# Permit Inspections Harnett County

**Permit Number: SFD2211-0027**

Description: **76x62 sfd 3 beds 3 baths**

Site Address: **721 RAMBEAUT RD**

Foundation Stem Wall Slab

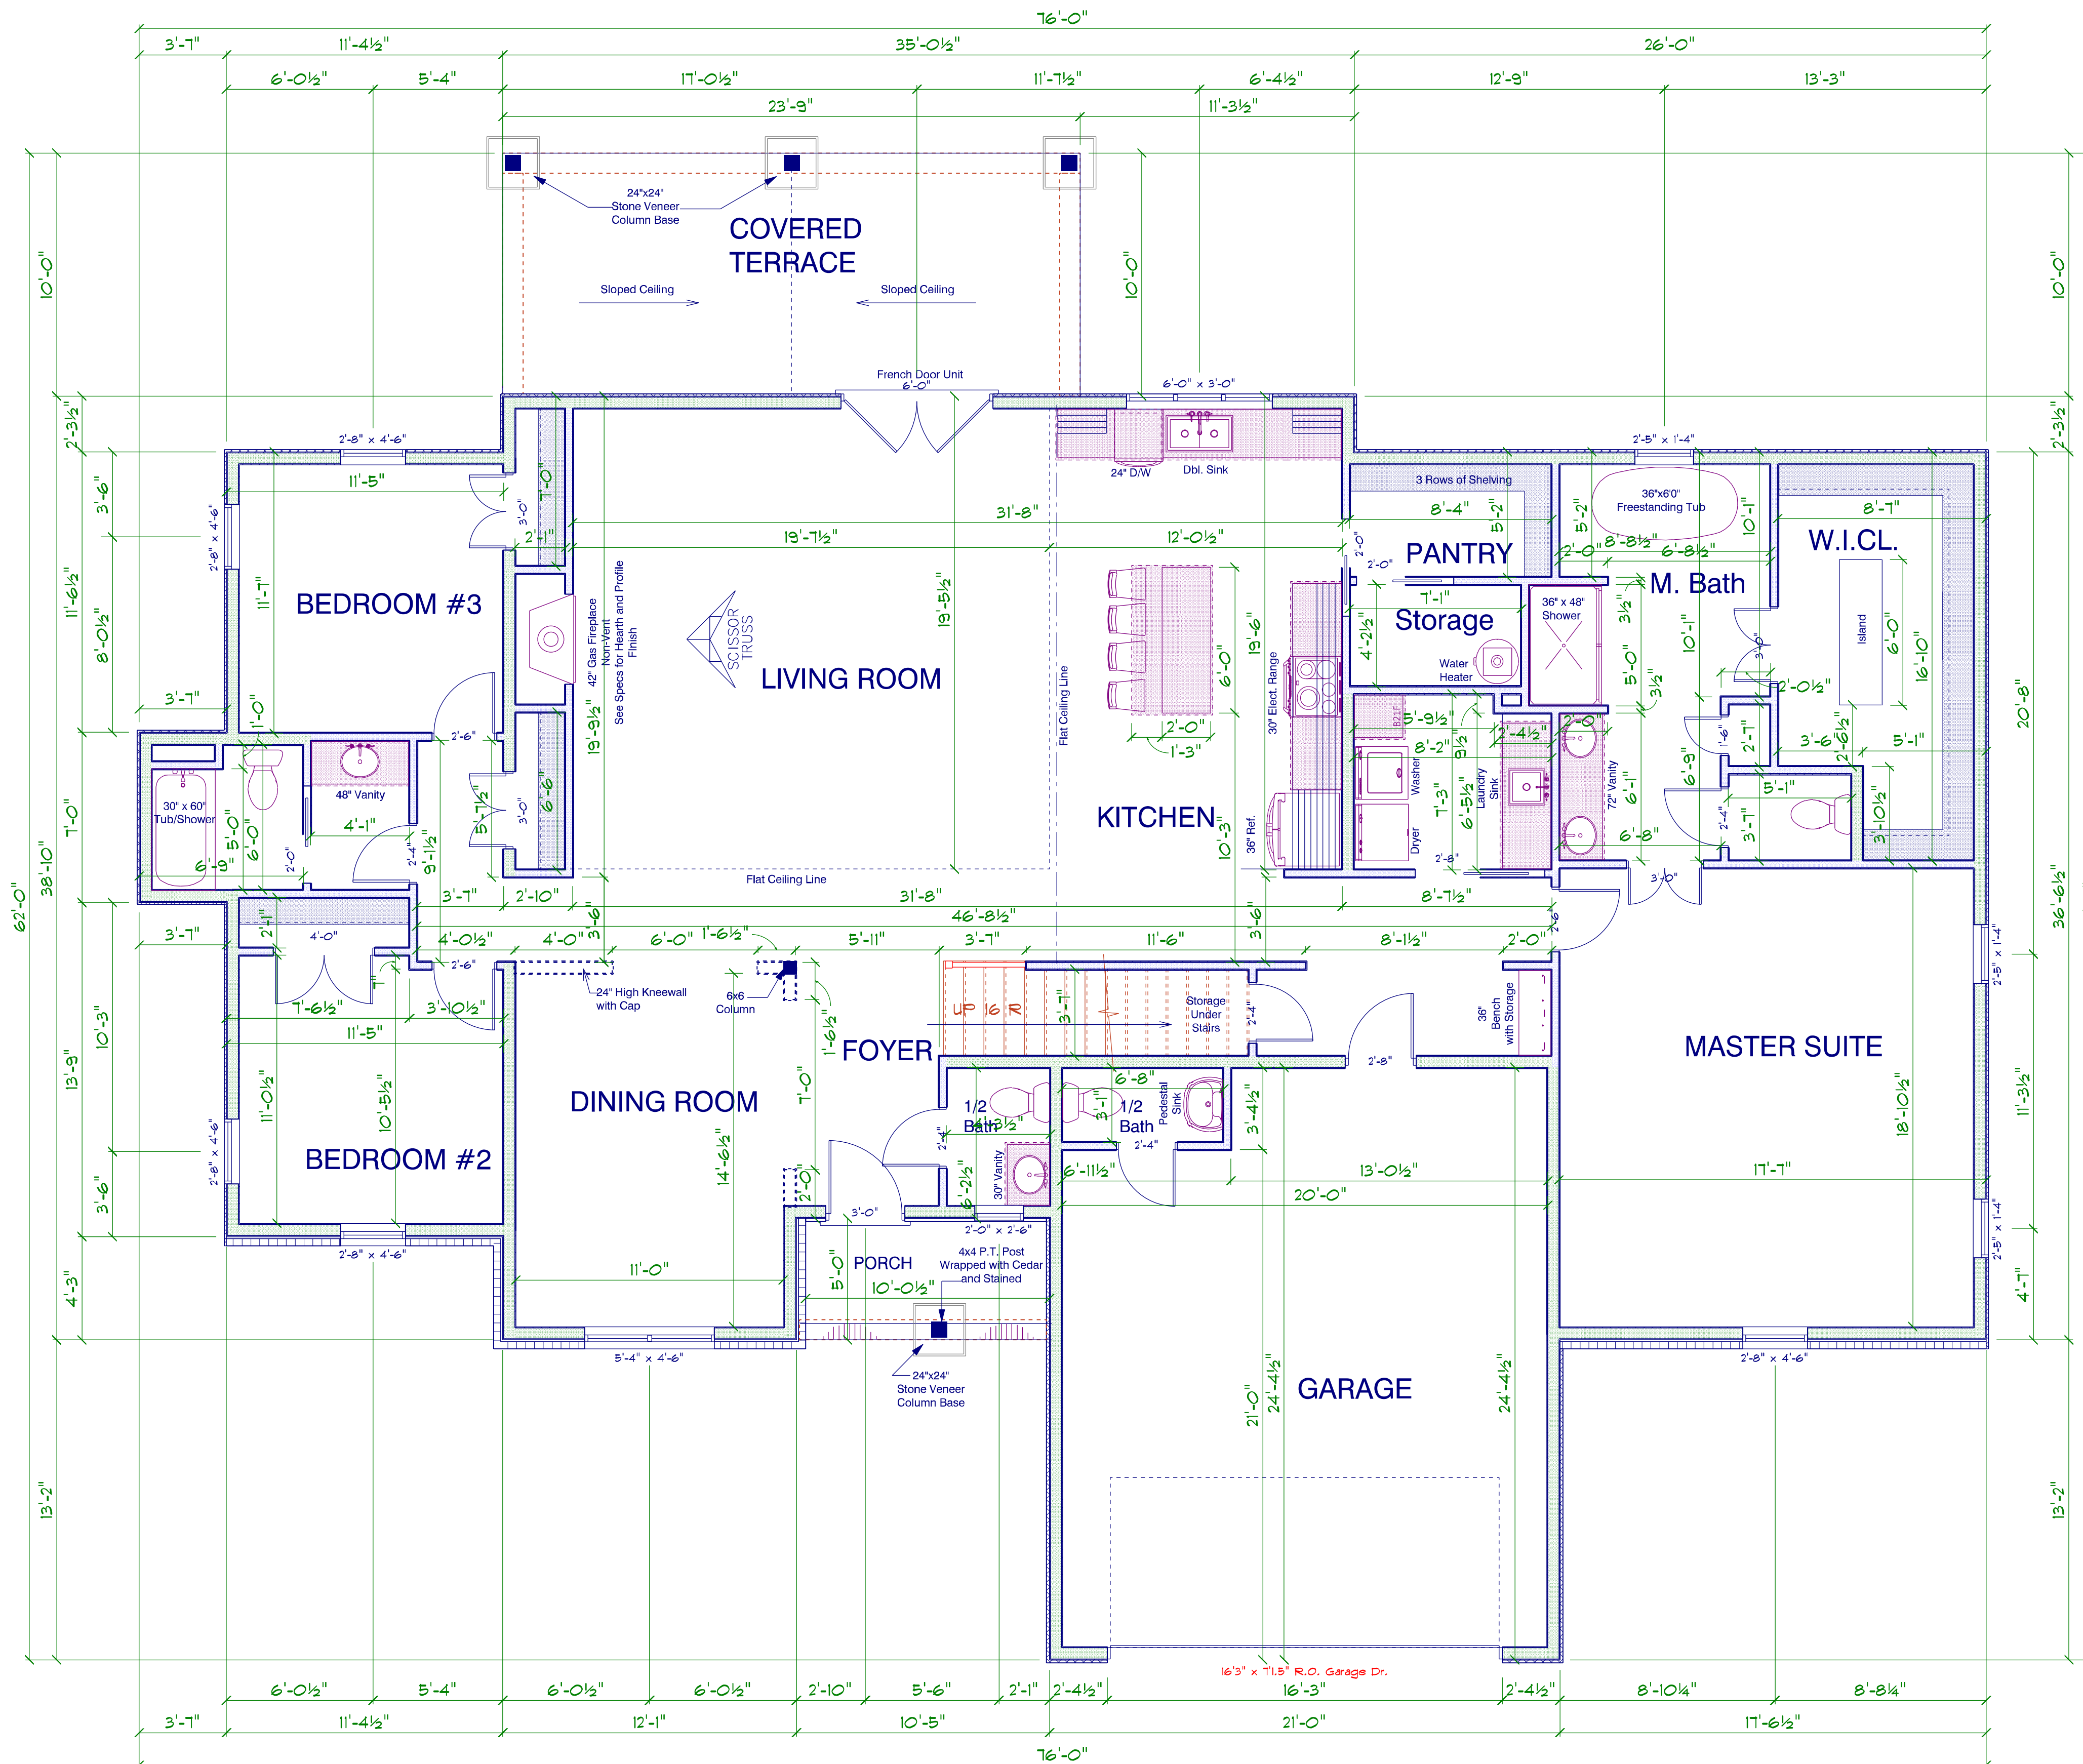
Notes:  
 Need continuous footing cross garage door opening clean loose dirt from footings

Notes:  
 Expose all footings for inspection Missing anchor bolts in foundation walls per code Missing R 10 insulation on foundation wall per code or res check

Need compaction letter for fill over 24"Missing lug footing for stairs behind back wall in garage
